Addendum No. 1

RE: Contract # C203934

Gaston County (I-5894)

I-85 FROM MILE MARKER 22 TO MECKLENBURG COUNTY LINE

REVISIONS						SHEET NO.
NO.	BY:	DATE:	NO.	BY:	DATE:	TOTAL SHEETS
1			3			S-14
2			4			27

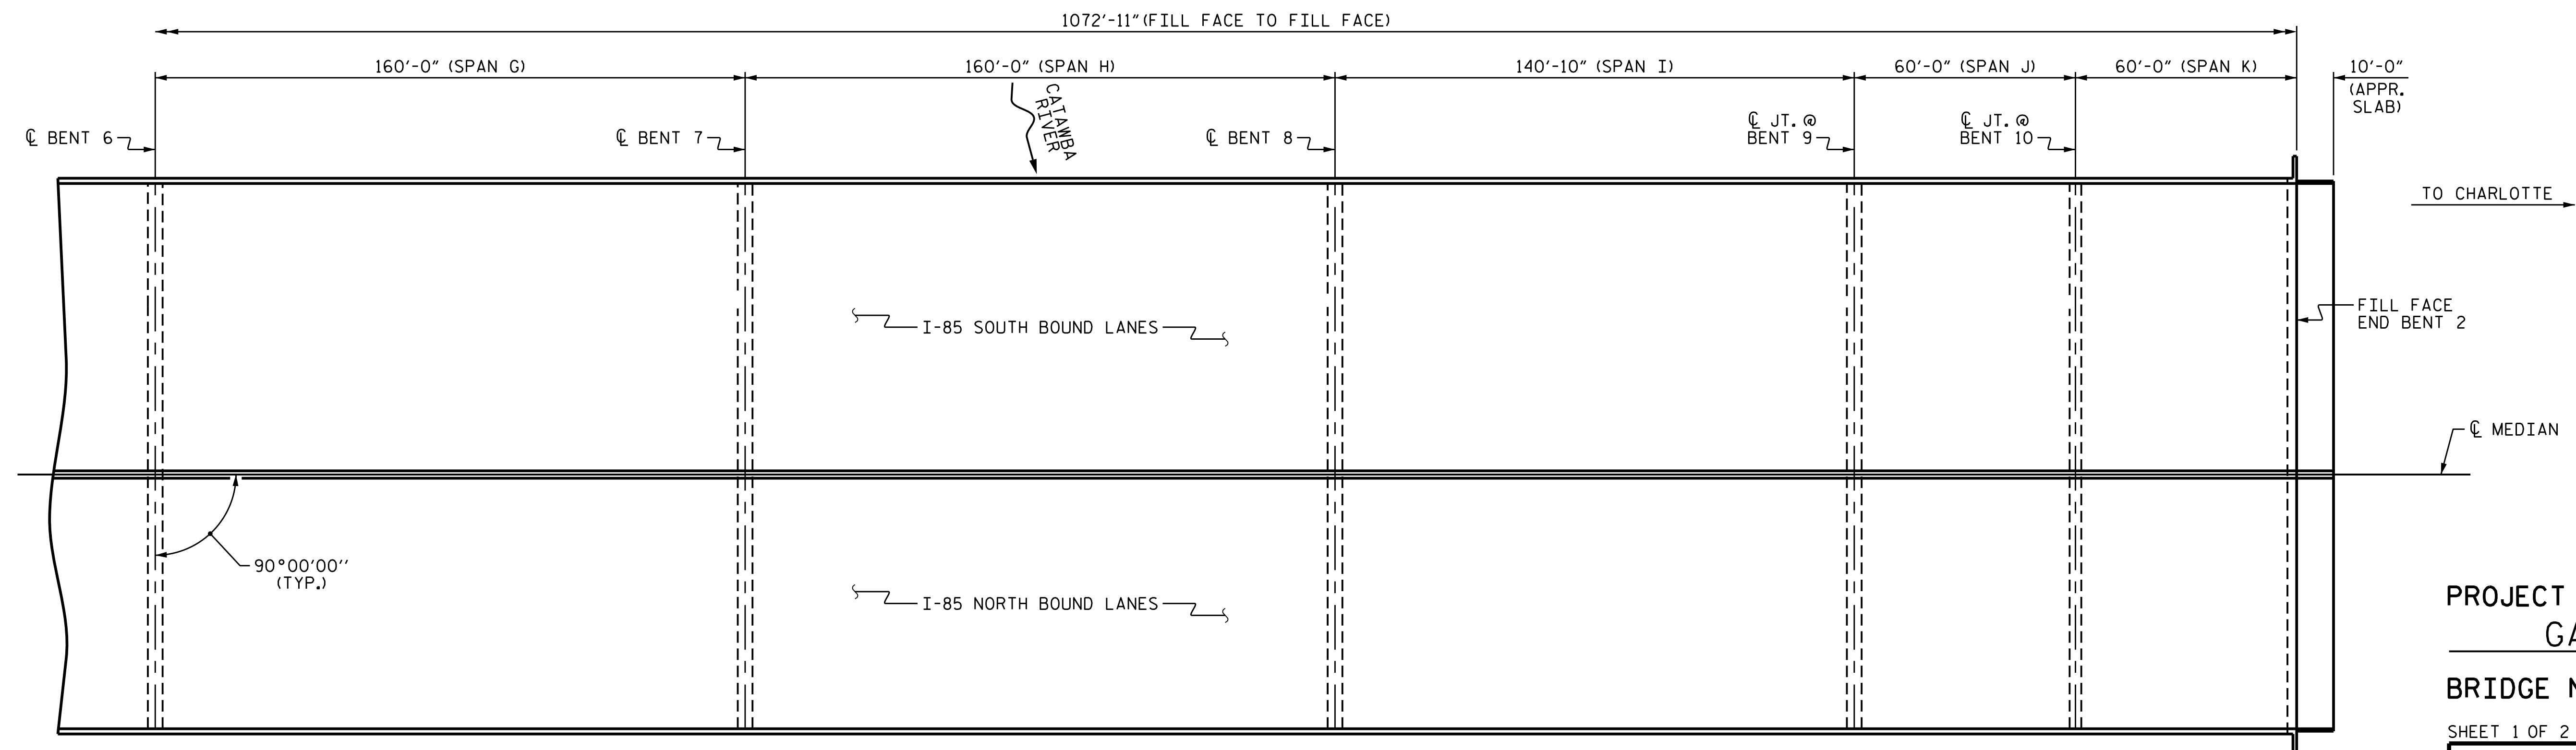
Sheet No.	Revisions
S-14	Revised PE Seal
S-15	Revised to show correct overhead image
